Rezoning Petition Review

Rezoning Petition #: 20-02

Proposed Zoning: UR-2 (CD)

Location of Property: Approximately 0.55 acres located on the northeastern side of Vail Ave, south of Deacon Ave and southeast of Dotger Ave.

SCHEMATIC SITE PLAN

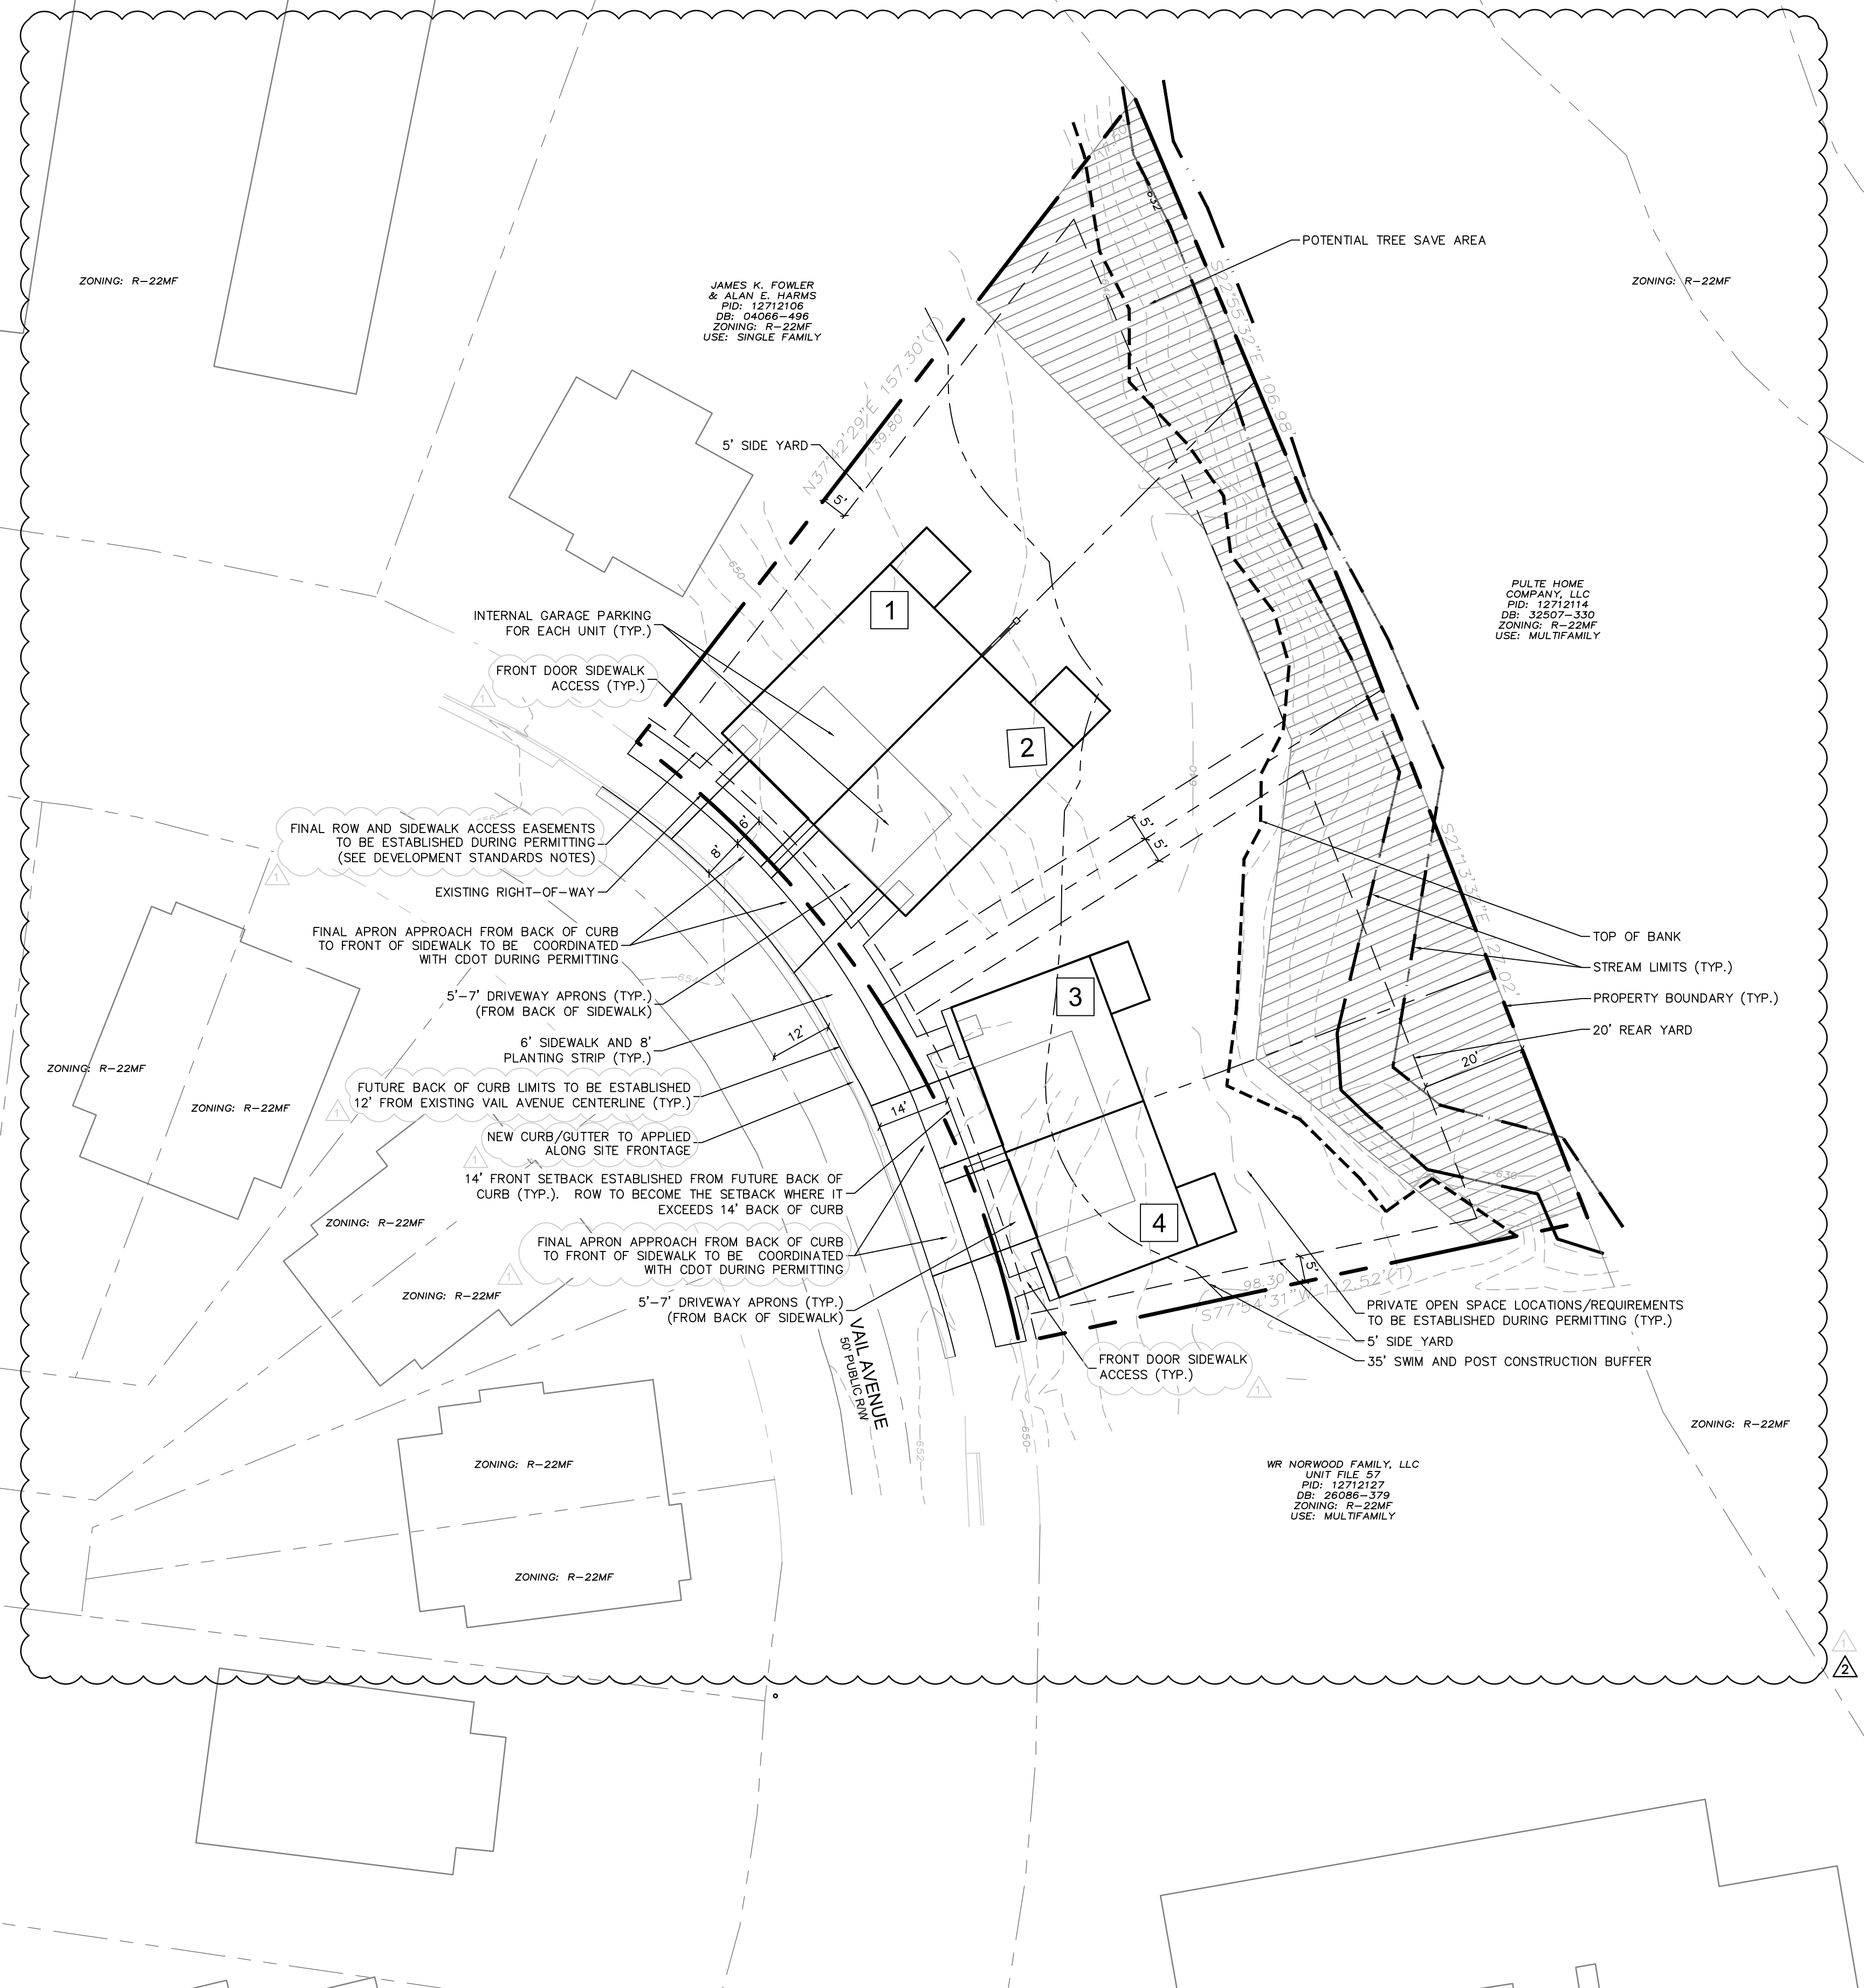
Please replace the second sentence under note #1 of "Environmental Features" with the following: *"Development within the SWIM/PCSO Buffer shall be coordinated with and subject to approval by Charlotte-Mecklenburg Storm Water Services and mitigated if required by City ordinance."* Please note Stream Delineation Reports are subject to review and approval by Charlotte Storm Water Services.

This property drains to Briar Creek, which is an impaired/degraded stream, and may contribute to downstream flooding. This project has the opportunity to mitigate future impacts to this stream, therefore, Storm Water recommends placing the following notes on the plan:

(I) Storm Water Quality Treatment

For defined watersheds greater than 24% built-upon area (BUA), construct water quality stormwater control measures (SCMs) designed for the runoff generated from the first 1-inch of rainfall for all new and redeveloped BUA associated with the project. SCMs must be designed and constructed in accordance with the Charlotte-Mecklenburg BMP Design Manual.

(II) Volume and Peak Control

For defined watersheds greater than 24% built-upon area, control the entire volume for the 1-year, 24-hour storm for all new and redeveloped BUA associated with the project. Runoff volume drawdown time shall be in accordance with the Charlotte-Mecklenburg BMP Design Manual.

For commercial projects with greater than 24% BUA, control the peak to not exceed the predevelopment runoff rates for the 10-yr, 6-hr storm and perform a downstream flood analysis to determine whether additional peak control is needed and if so, for what level of storm frequency, or if a downstream analysis is not performed, control the peak for the 10-yr and 25-yr, 6-hour storms.

For residential projects with greater than 24% BUA, control the peak to not exceed the predevelopment runoff rates for the 10-year and 25-year, 6-hour storms or perform a downstream analysis to determine

whether peak control is needed, and if so, for what level of storm frequency.
